Shoalhaven Starches Development Consent 06_0228 Independent Odour Audit 2024 - Response to Audit Recommendations

Table 1 – AUDIT NON-COMPLIANCES

Table 2 – AUDIT RECOMMENDATIONS

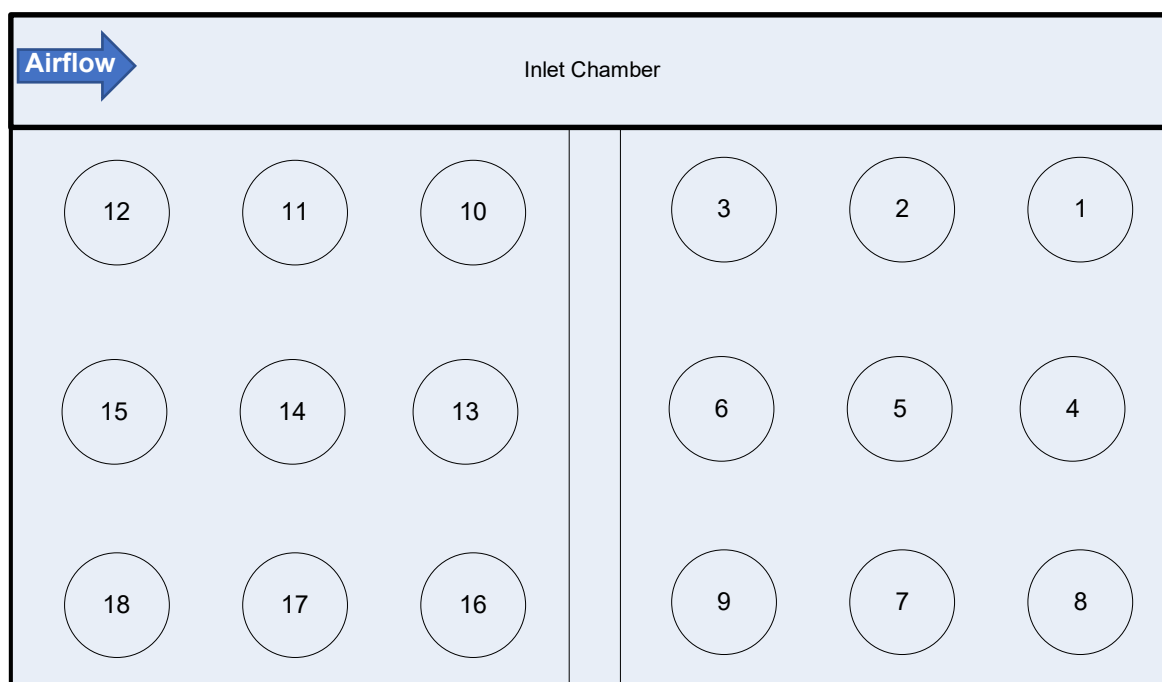
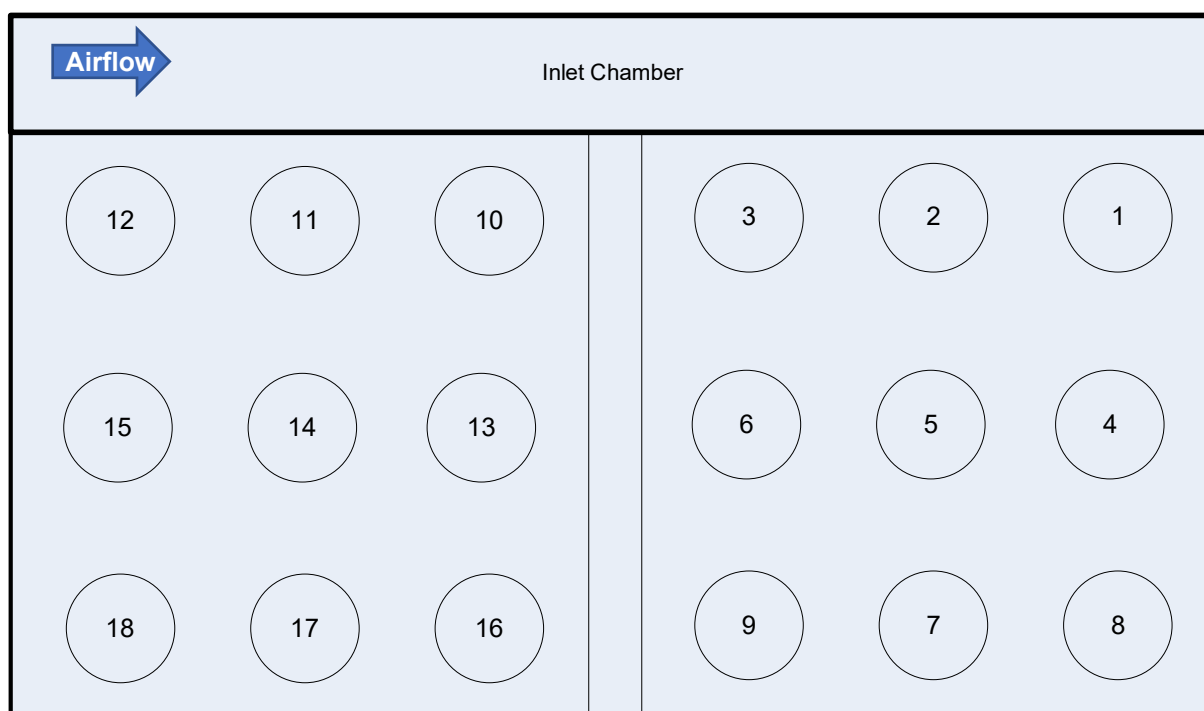
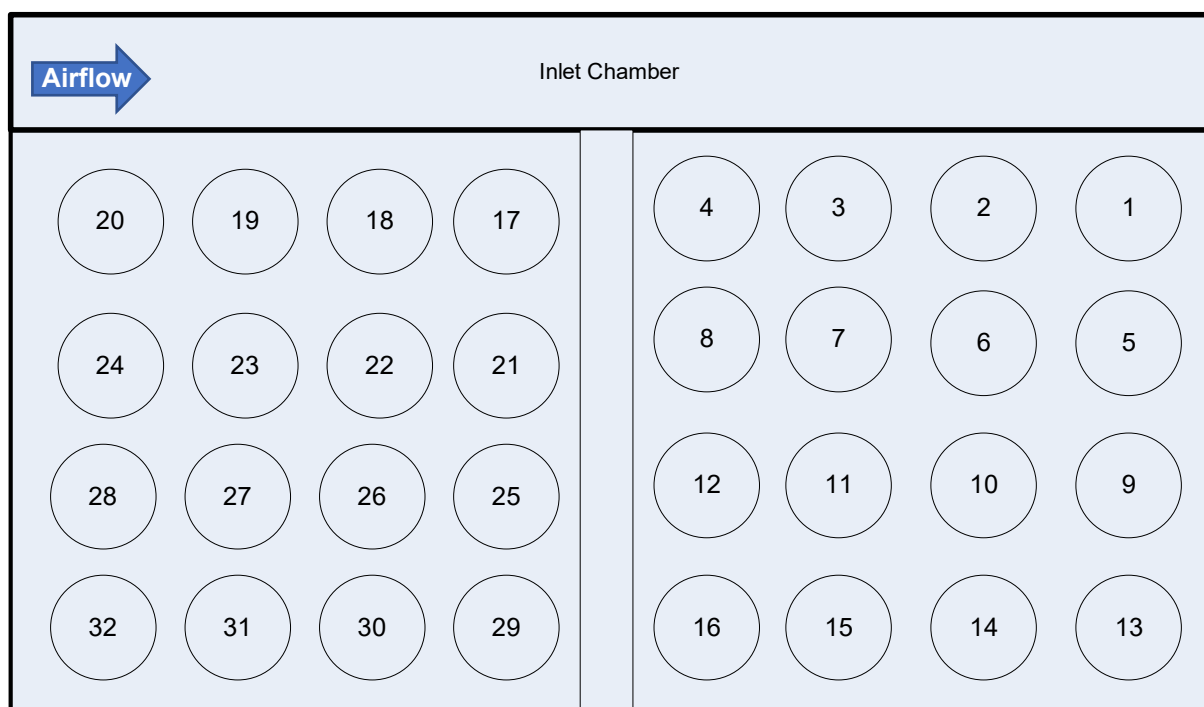
Audit Reference	Audit Report Recommendations	Shoalhaven Starches (SS) Response	Timeframe	Status
23/24-REC-A	Based upon the data presented in Table 5, the biofilters are not achieving the de facto 500 OU standard and are not achieving a satisfactory degree of odour control (measured as 8 % efficiency). It is acknowledged that Shoalhaven Starches have recently brought a third biofilter online (Biofilter C) to redistribute the flow to achieve the design capacity flow rate through all biofilters.	The new Biofilter C constructed in 2024 has doubled our current odour treatment capacity in this area. By spreading the incoming air flows over a significantly larger surface area it is anticipated to significantly improve biofilter performance. Initial rounds of post-commissioning testing and Quarter 1 results have indicated that destruction efficiency has increased to >90% across the average of the biofilters. Further results are required to verify the improvements.	May 2025	In progress. Biofilter C installed in May 2024
